City of Portland, Maine - Building or Use Permit Application

Permit No: 02-1173	Issue Date: NOV - 10	CBL: 376 A053001
-----------------------	--------------------------------	---------------------

Past Use: Vacant Land	Proposed Use: Single Family / New 28' x 28' w/ 10' x 24' back "L" home; including 24' x 24' two car attached garage and 12' x 16' deck	Permit Fee: \$1,498.00	Cost of Work: \$200,000.00	CEO District: <i>Subdiv</i>
--------------------------	---	---------------------------	-------------------------------	--------------------------------

Application ID Number: 2-1173

Drawing Name: **Site Layout & Utilities Plan**
 Project: **LOT 3 - NORTHGATE FARMS, PORTLAND**

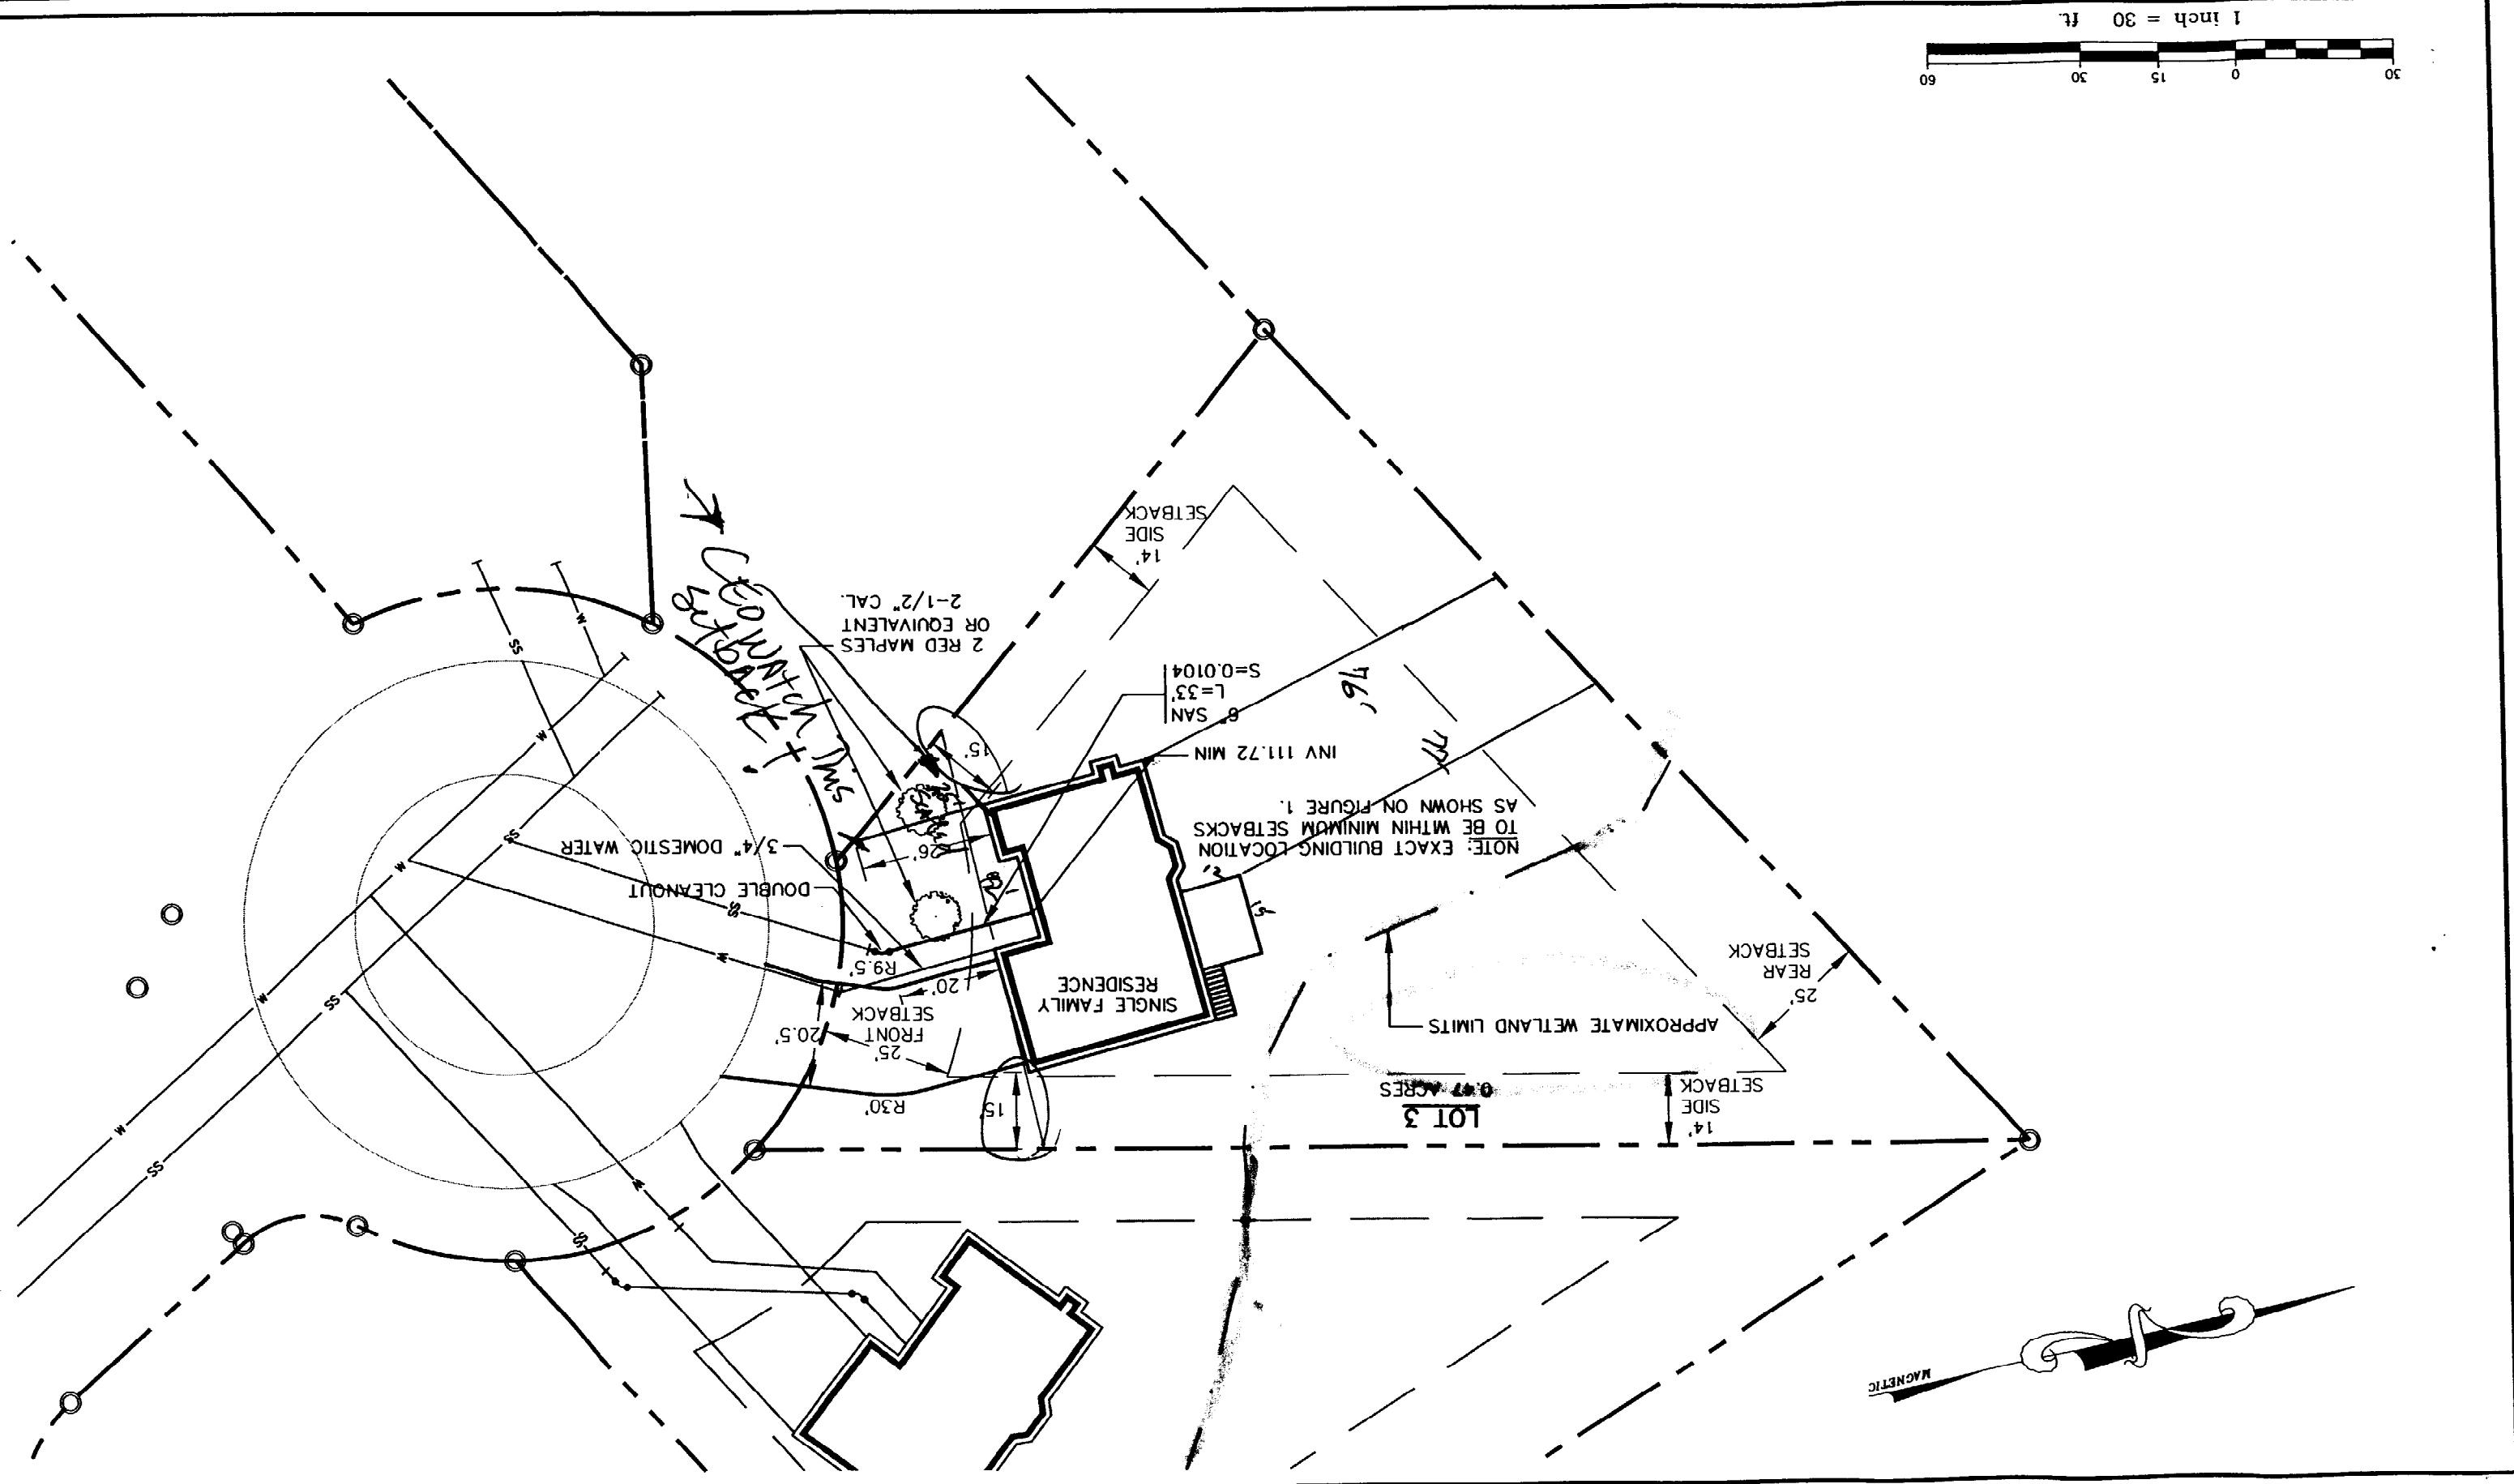
garage
ex
9' x 24.5'
~~24' x 24'~~
rear deck 12' x 16'
stairs

LEO check → Front Yard - 25' req - 25' shown - Scaled

Rear Yard - 25' req - 76' Scaled

Side Yard - 14' req - 15' & 15' shown

Width of Lot - 75' req - 82' Scaled

Height - 35' MAX - 31' Scaled
